From: [REDACTED]
Sent: 03 September 2023 13:58
To: Planning
Subject: Planning app 3/2023/0634

Planning Application Reference No.: 3/2023/0634

Address of Development: Primrose House, Primrose Road, Clitheroe BB7 1DR
Grid: 373684 440649

Comments: Comments relate to the tree plan, fence line & ecological appraisal.

**EXISTING LAYOUT**

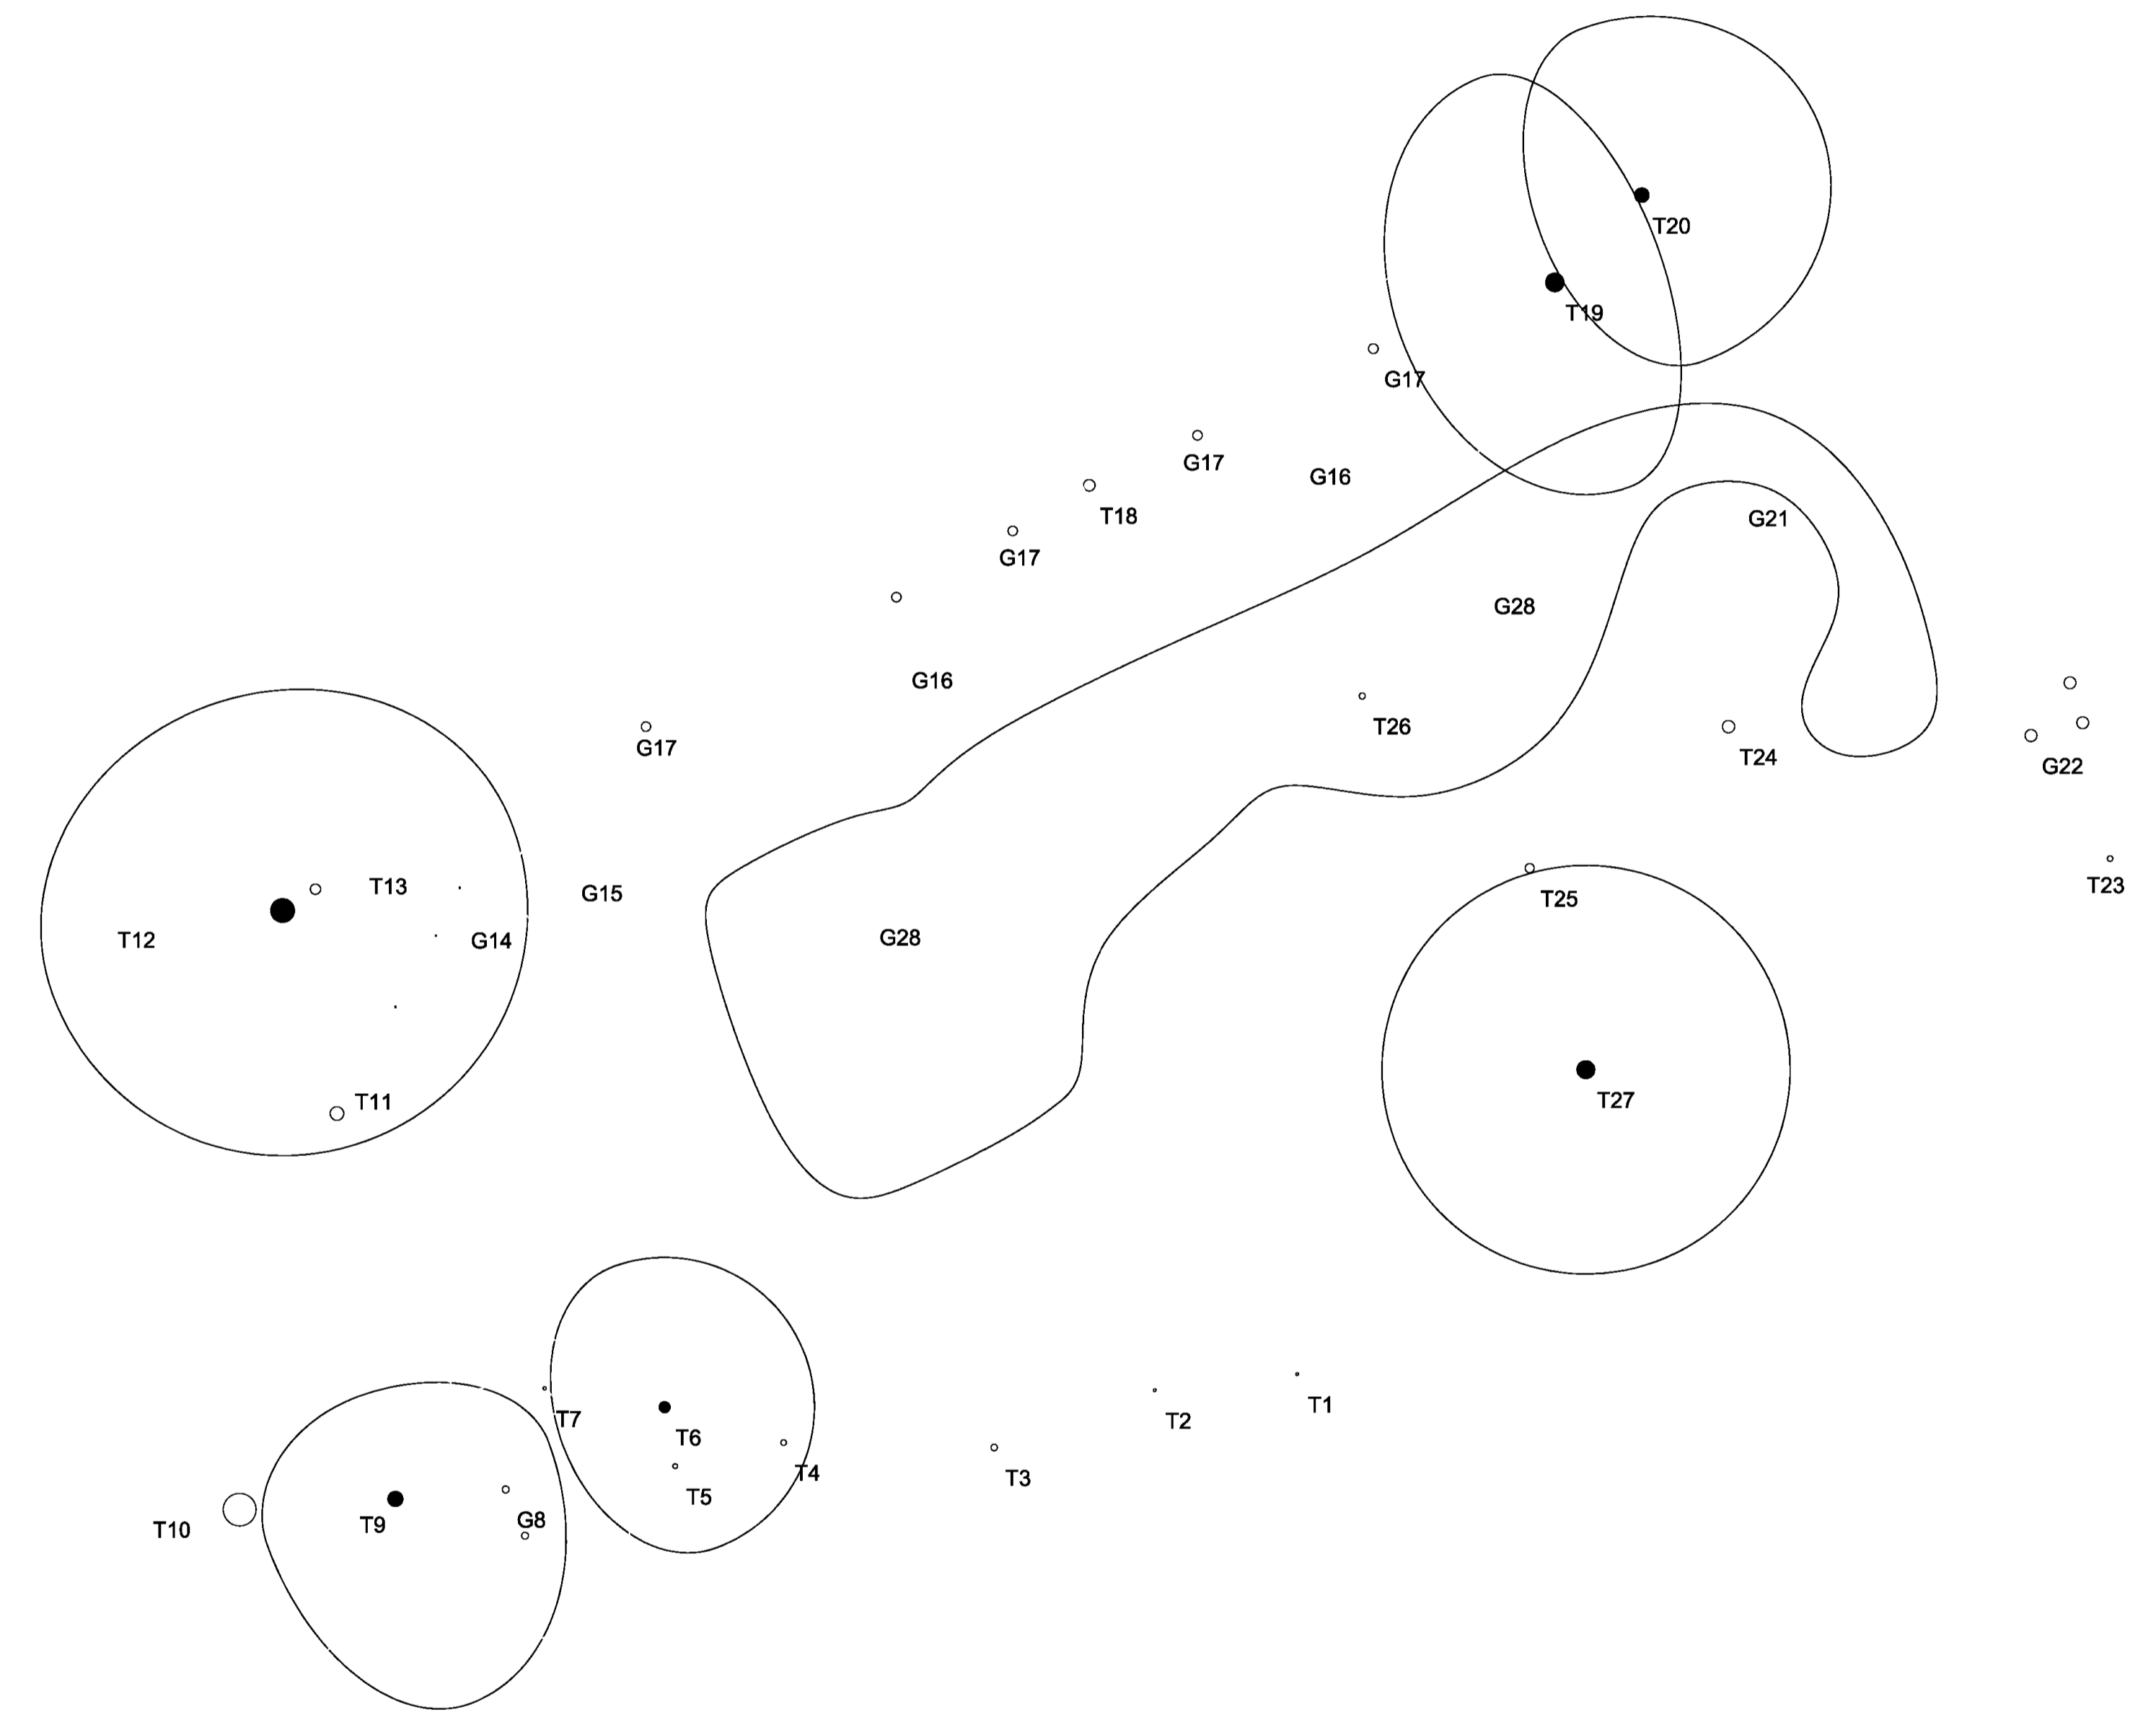
[REDACTED] fence line & where most of the trees are proposed to be removed would it be possible to arrange a walk of the site [REDACTED] exactly which trees are due to be impacted. the plans a clear but an actual for some would put minds at rest.

<b>ROOT PROTECTION AREA (RPA)</b>
--	-----------------------------------

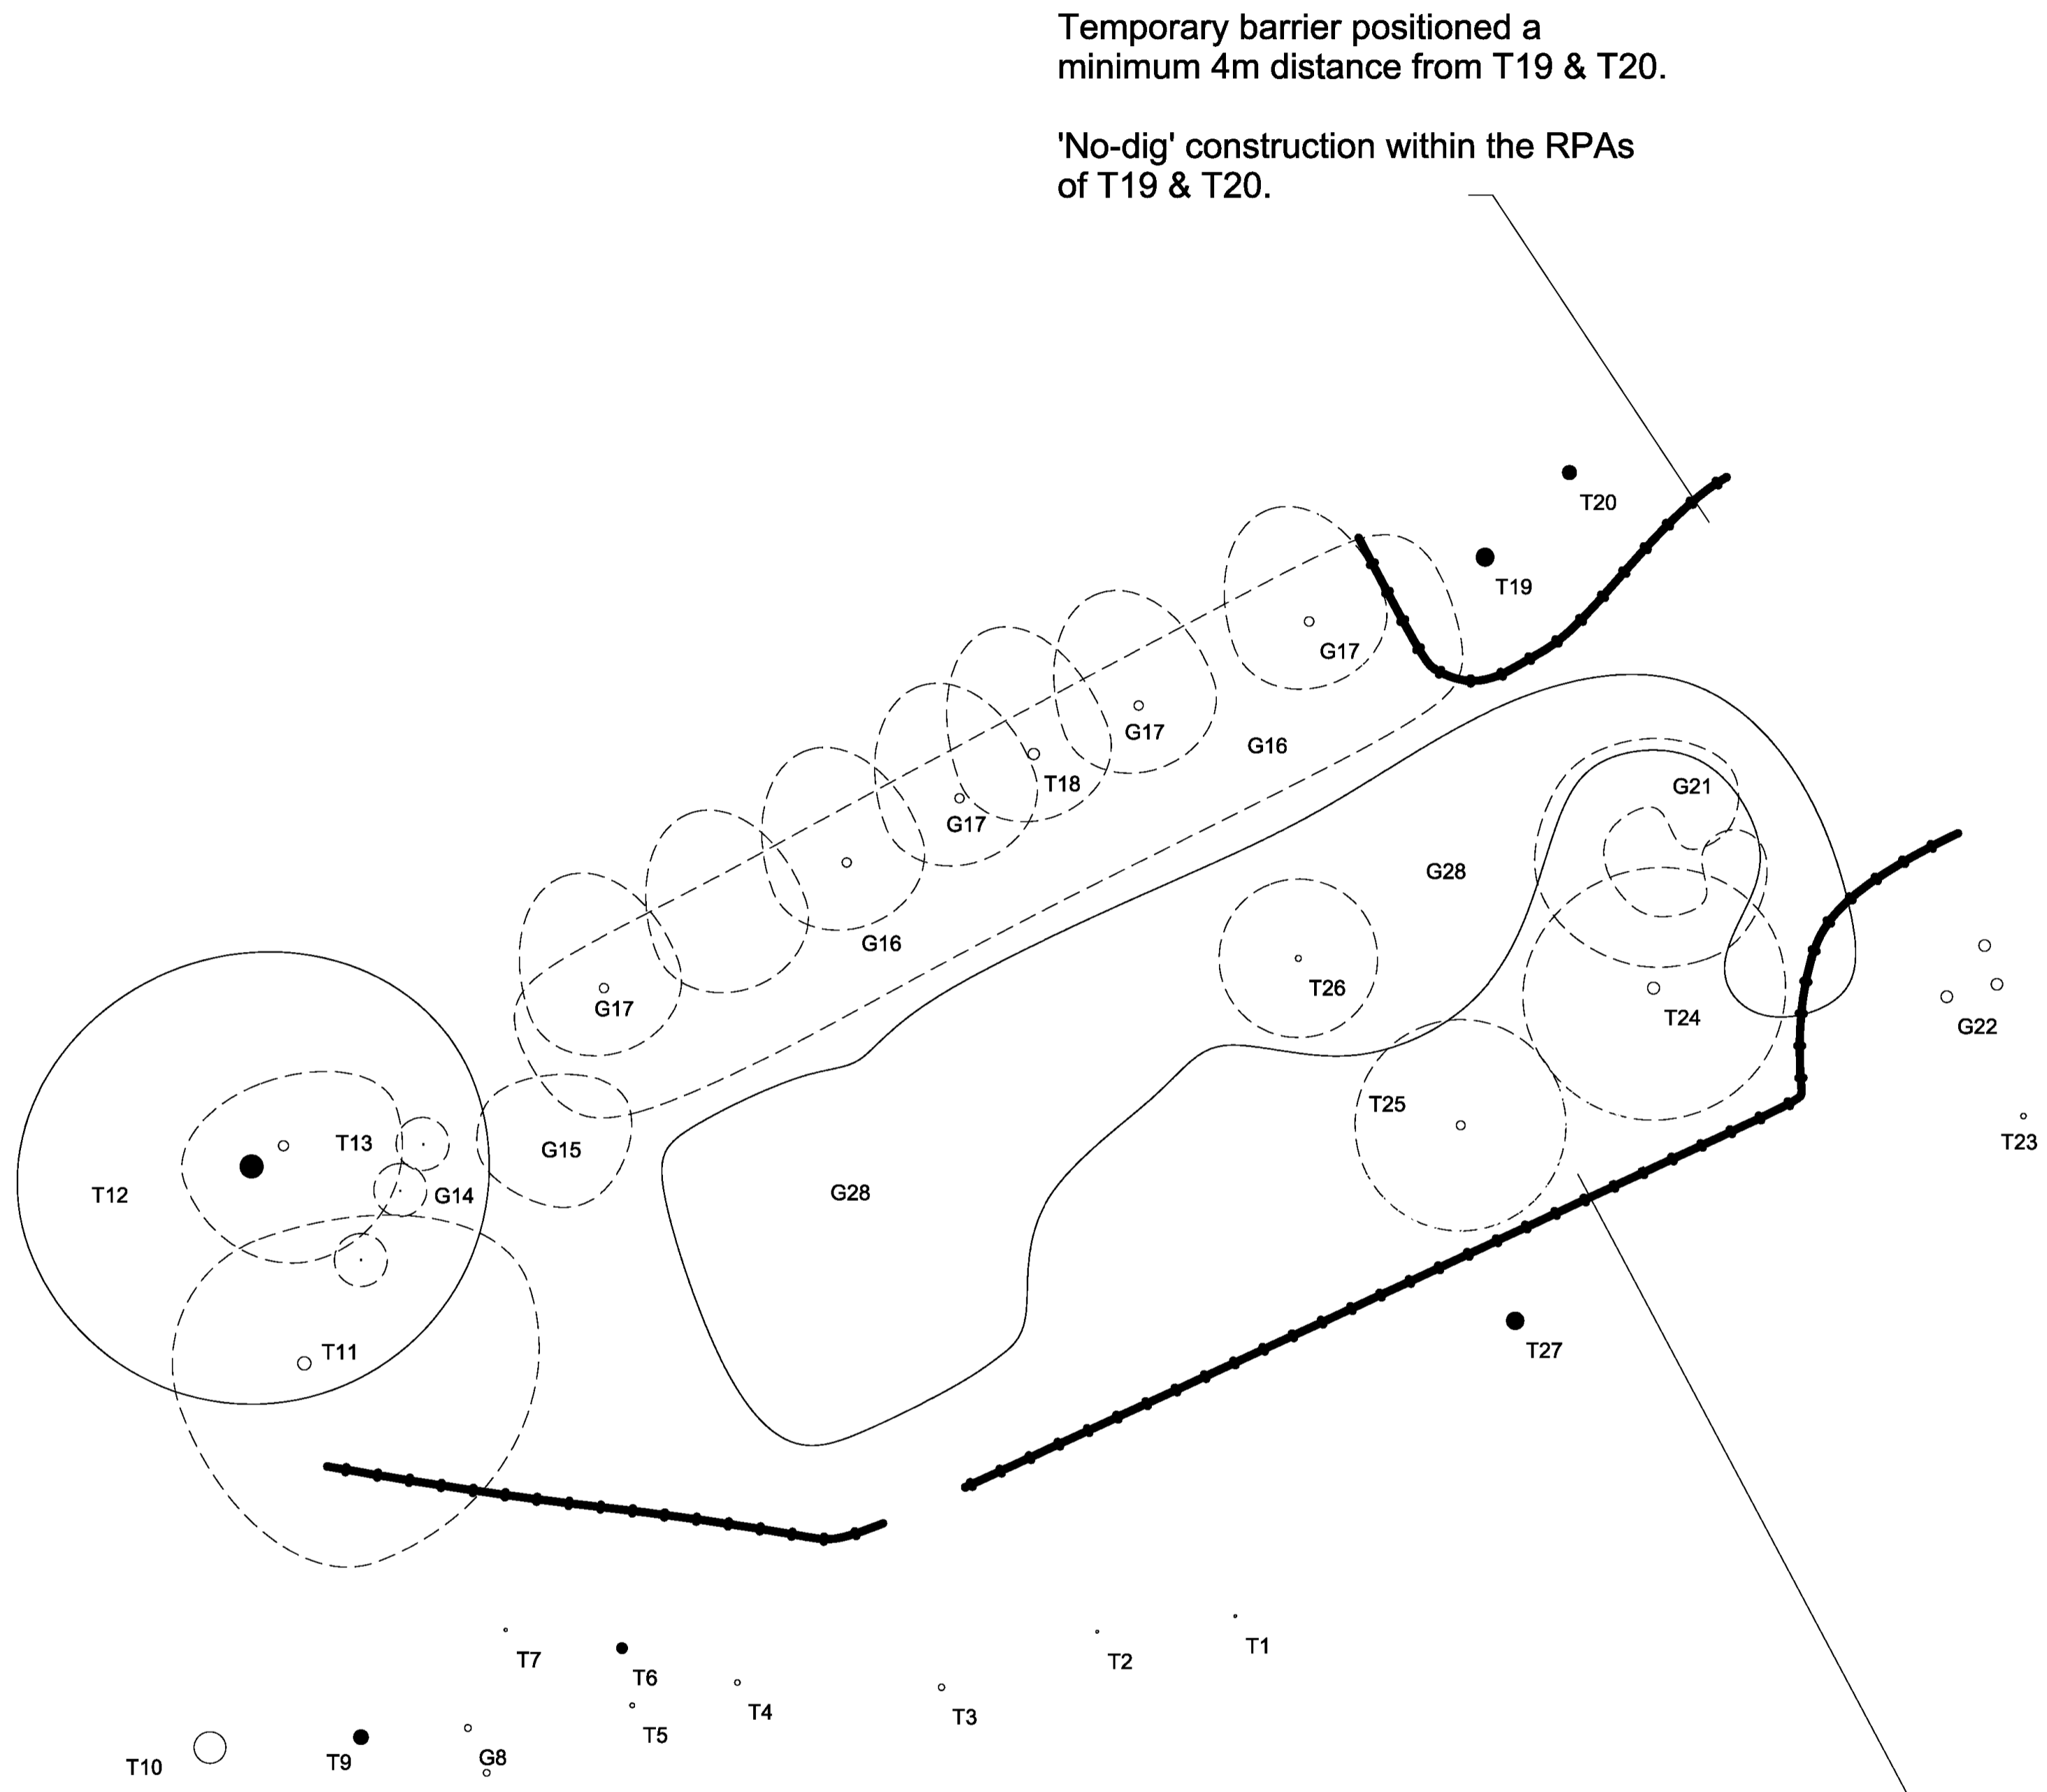
The two trees T19 & T20 are to remain with protection & root protection to the hard surfaced driveway. Once work commences can a guarantee be in place that these trees remain, there are mitigating plans & processes but what happens if these are not followed and 12 months after the completion the trees are removed - is this against the law?
